# Householder Proforma

**Application Ref:** 2021/1097  
**Address:** 55 Champany Fields, Dodworth, Barnsley, S75 3TS  
**Neighbour Representations:** No  
**Consultations:** None  
**Property Description:** the modern detached dwelling is constructed from buff brick with a concrete tiled roof and is located in a purely residential area of similar styled properties.  
The dwelling benefits from a small garden to the front and off street parking for at least 2no vehicles to the side and front of the property.

**Proposed Extension:** Erection of single storey extension to the side and rear of dwelling

**PROPOSED PLANS**

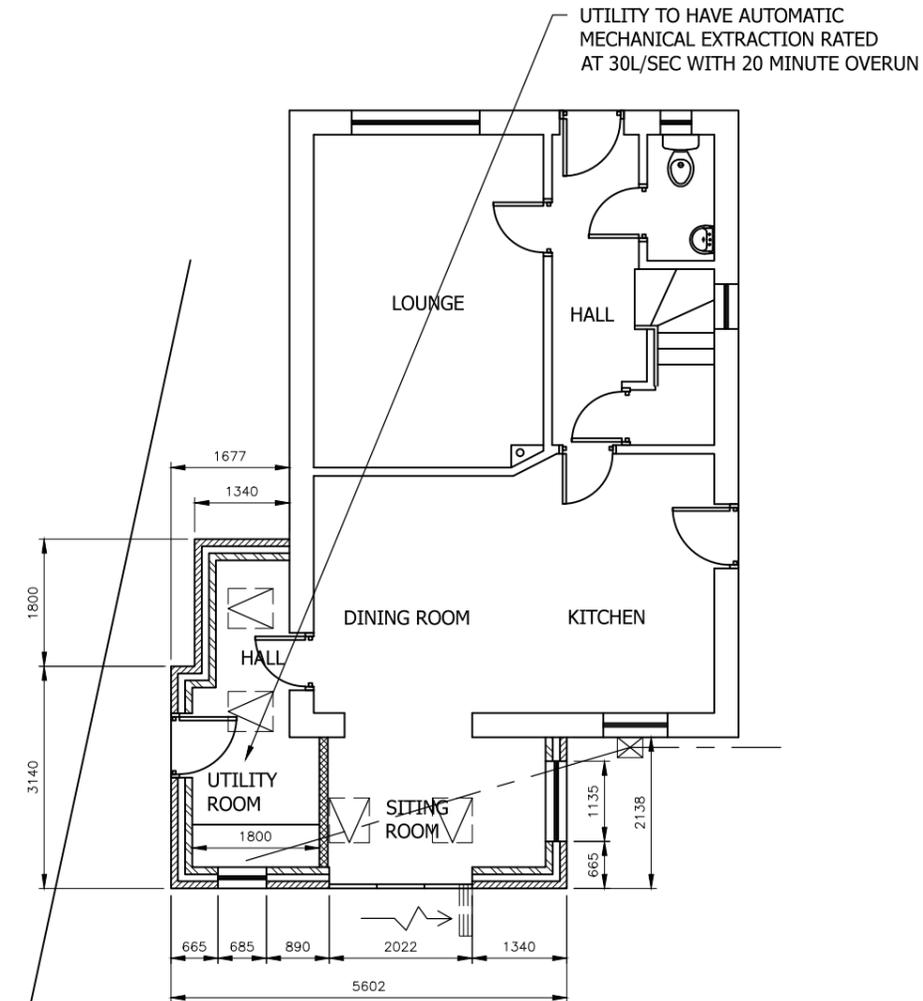
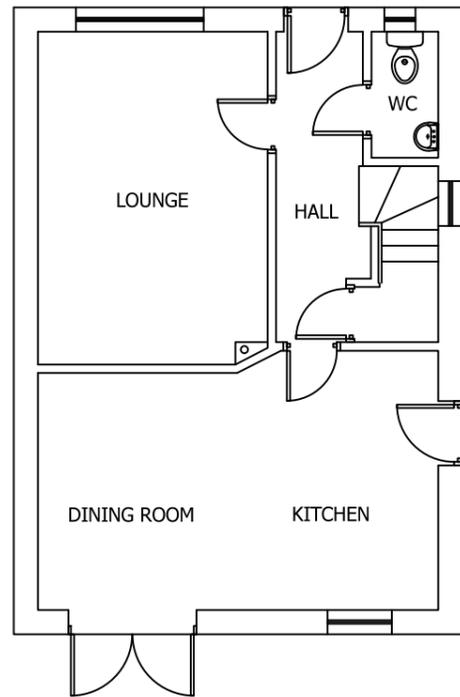
The applicant seeks permission for the erection of a single storey side and rear extension. The side extension is to be located on the south western side elevation and is set back approximately 6m from the front elevation of the dwelling and is to wrap around the rear elevation, extending 2.1m beyond the rear elevation and extending 4m along it.

The extension is set in 5.2m from the north eastern side boundary with the neighbouring property, whilst a window is proposed on this elevation, it is considered that the set in from the boundary and the inclusion of the existing boundary treatment would prevent increasing levels of overlooking.

There are no habitable room windows proposed on the south western elevation.

PROPOSED ELEVATIONS

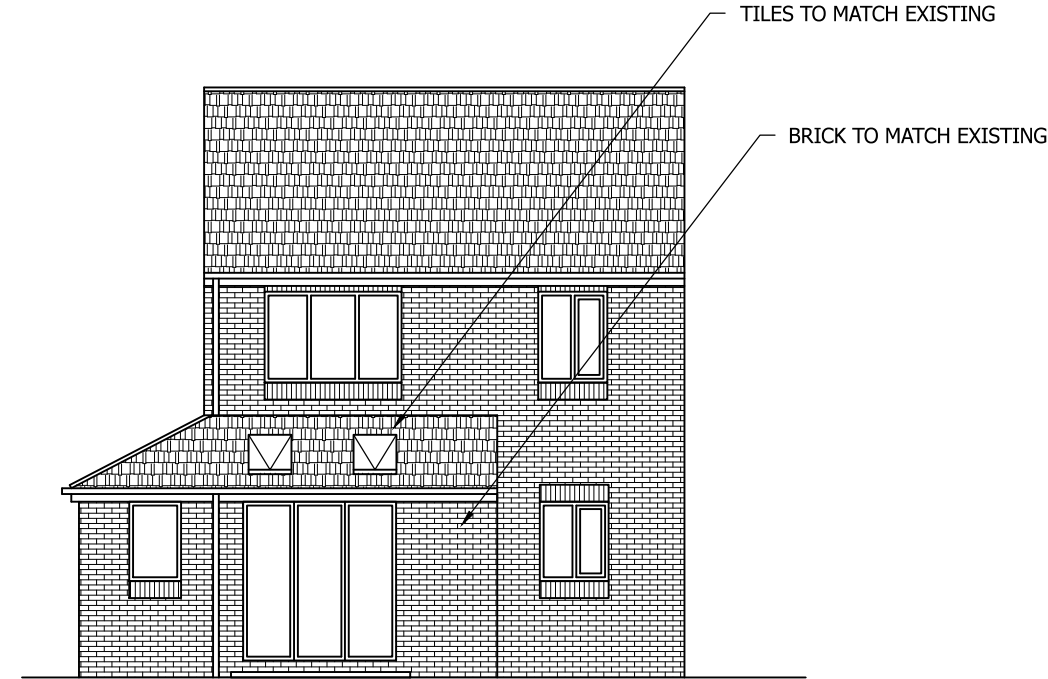
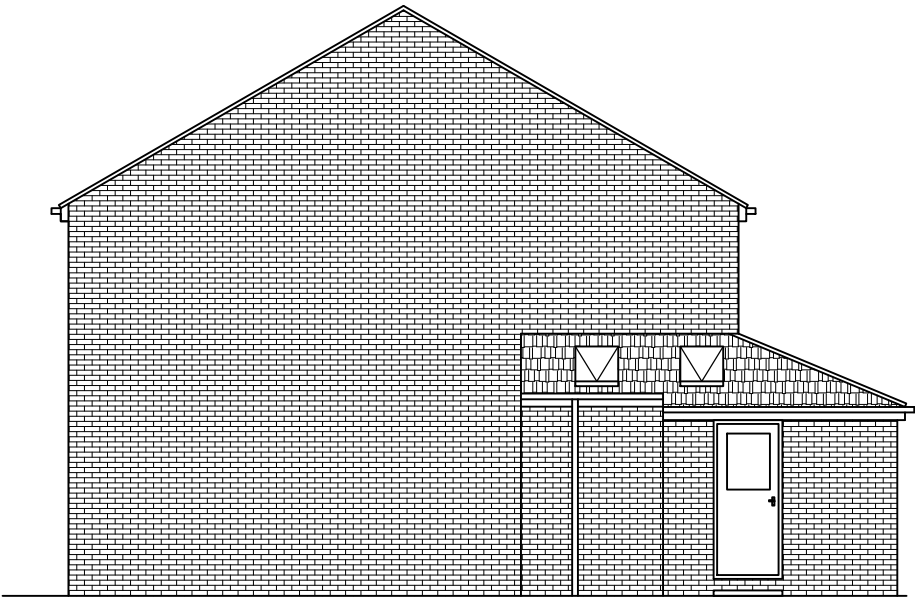
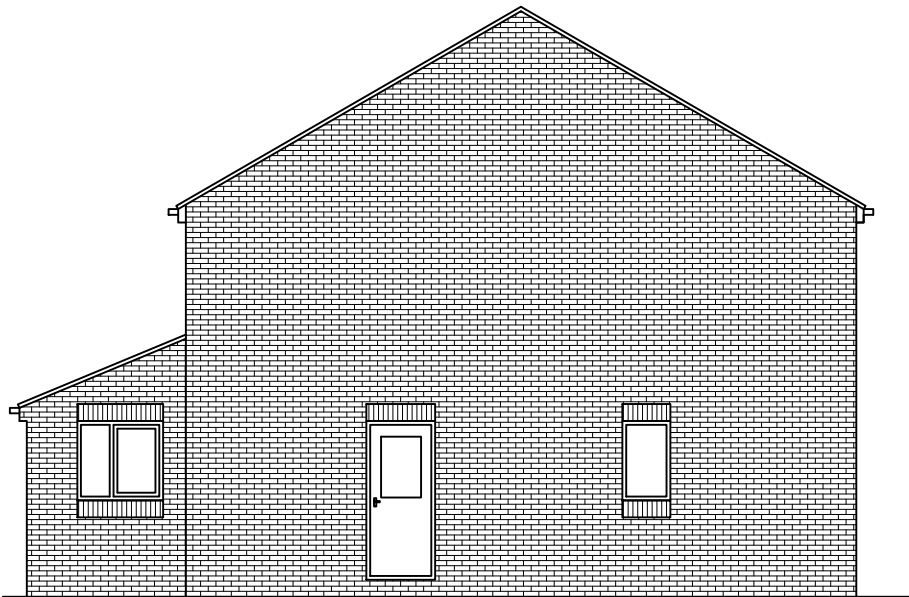
The extension is to be constructed from materials which match the original dwelling and is designed to harmonise with the dwelling in terms of roof style and pitch.
